MASTER DEVELOPMENT DRAINAGE PLAN & FINAL DRAINAGE REPORT

MONUMENT ACADEMY

Engineering Review

**JPS Project No. 040201
PCD File No. SP-19-
PPR-19-009**

EX2

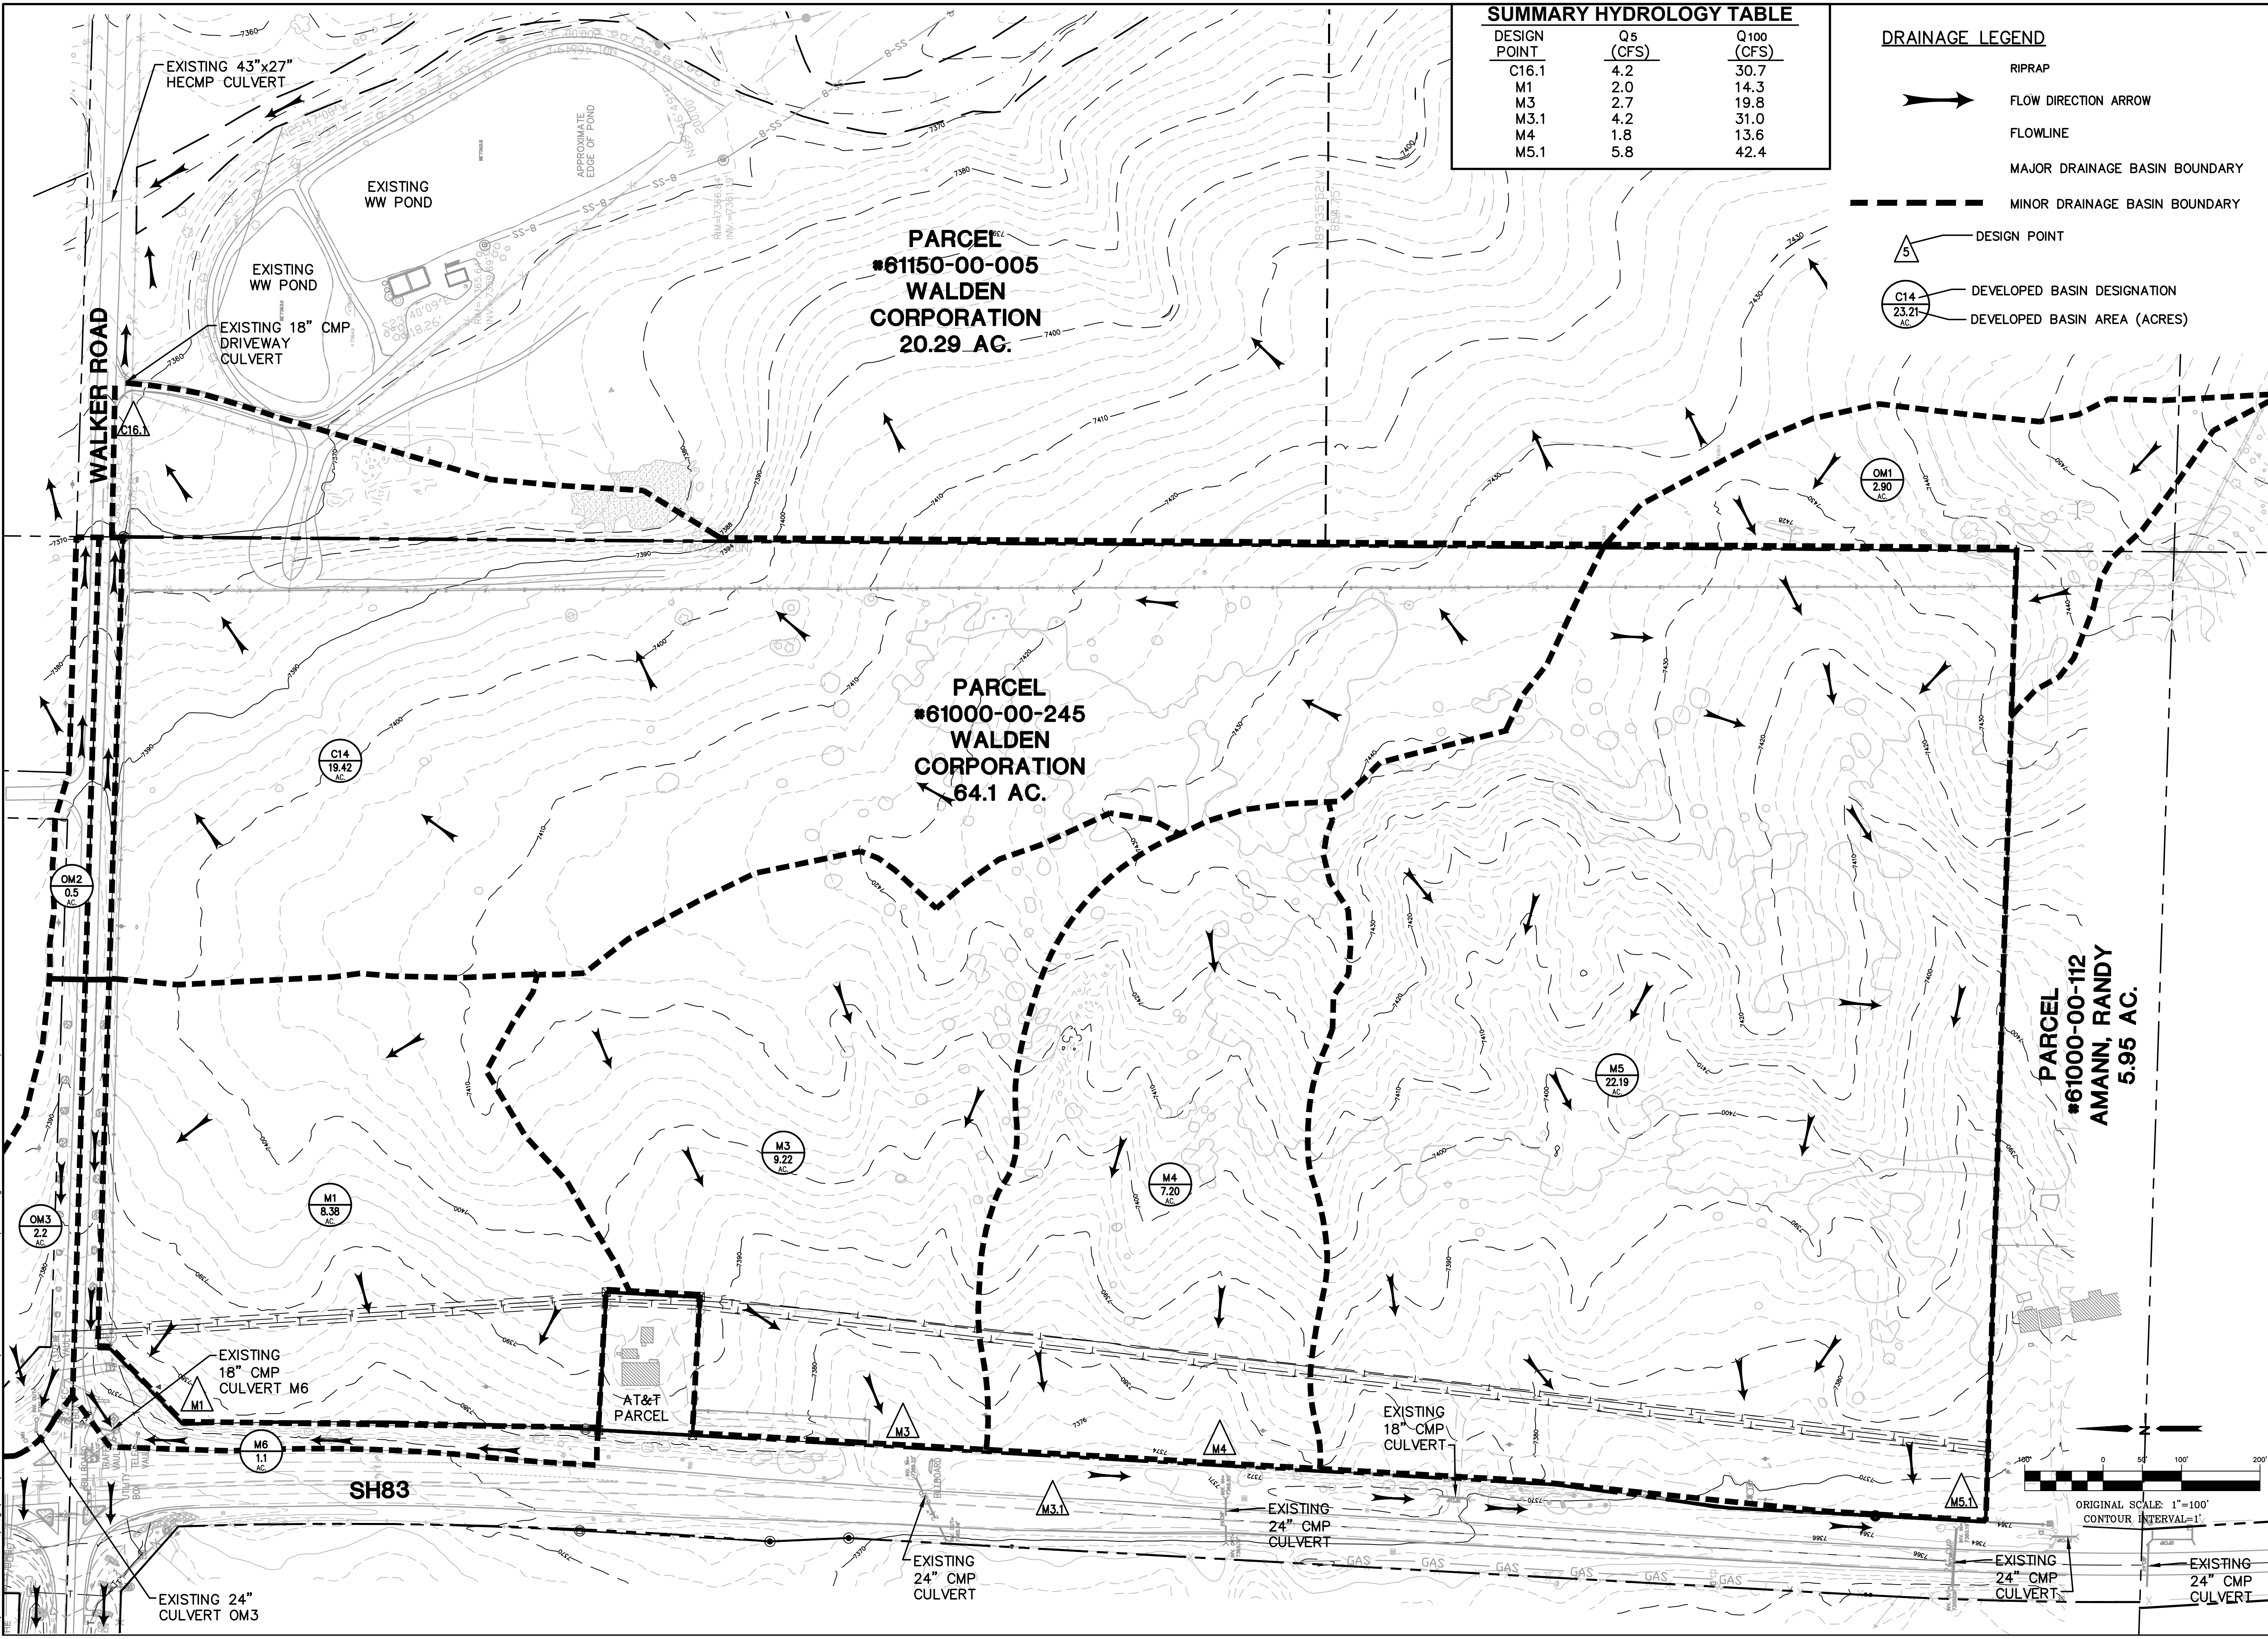
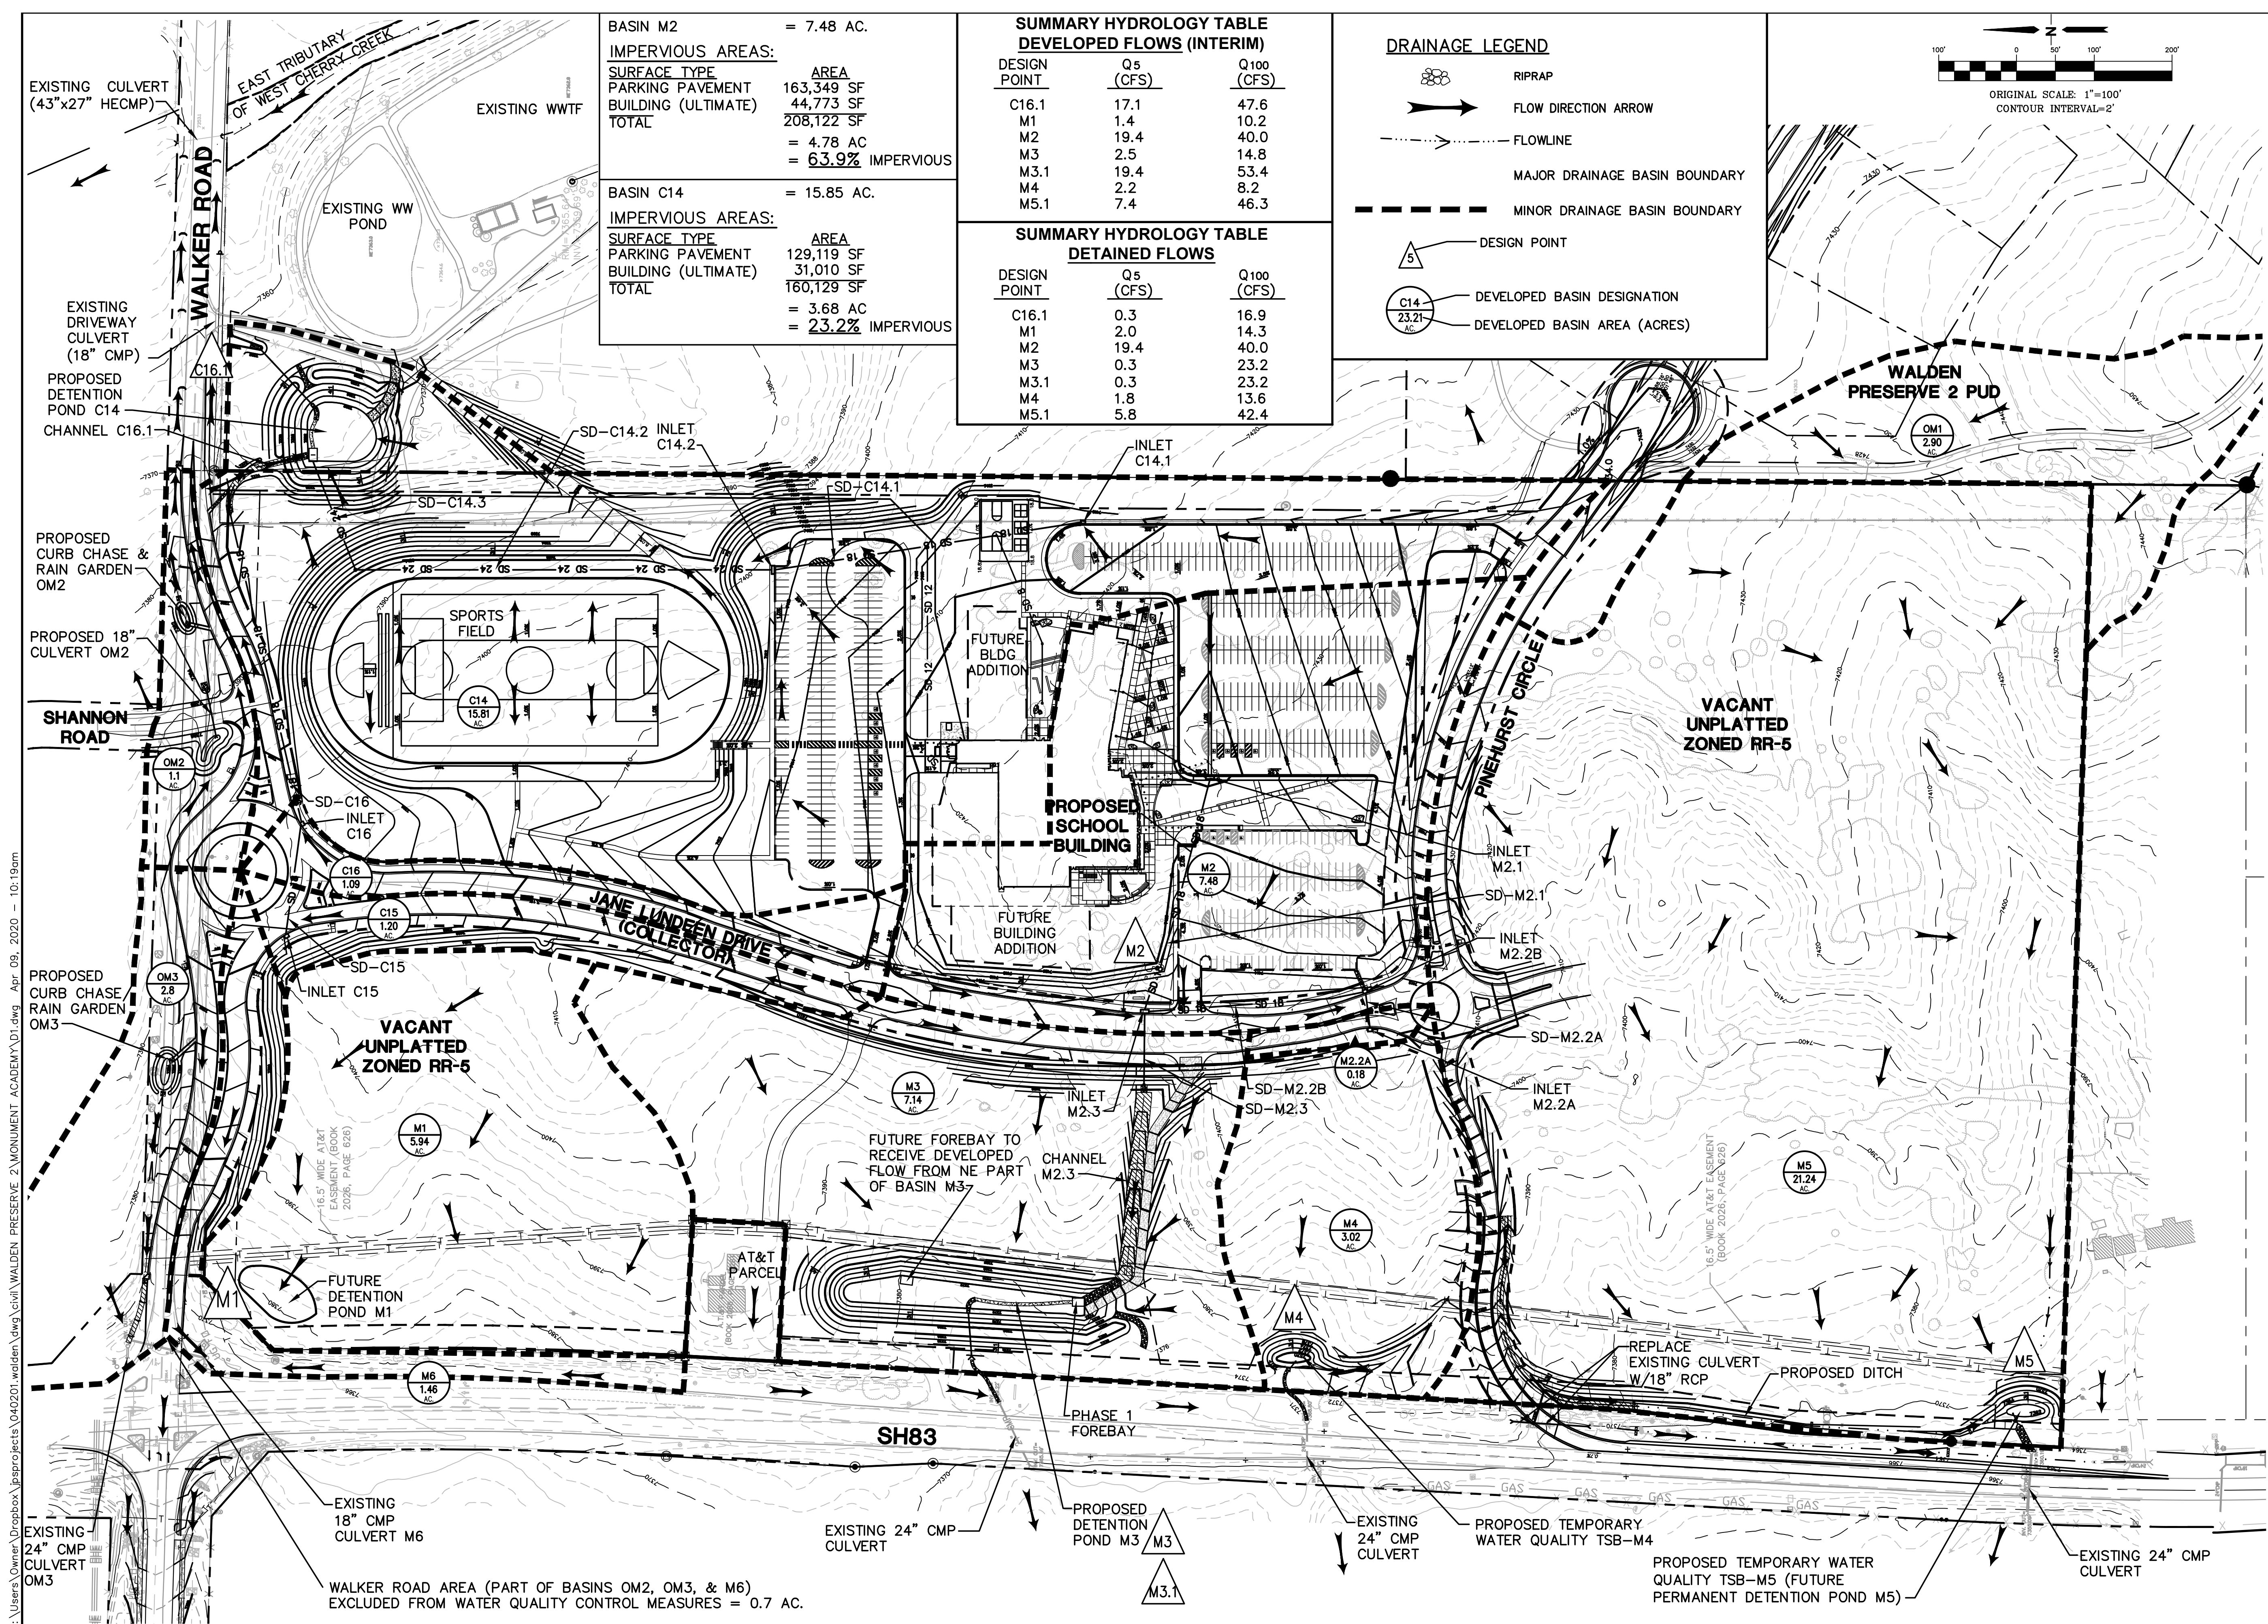
Address capacity of this culvert
and the upstream driveway
culvert.

split for each culvert

Address culvert capacity and
headwater for each culvert.
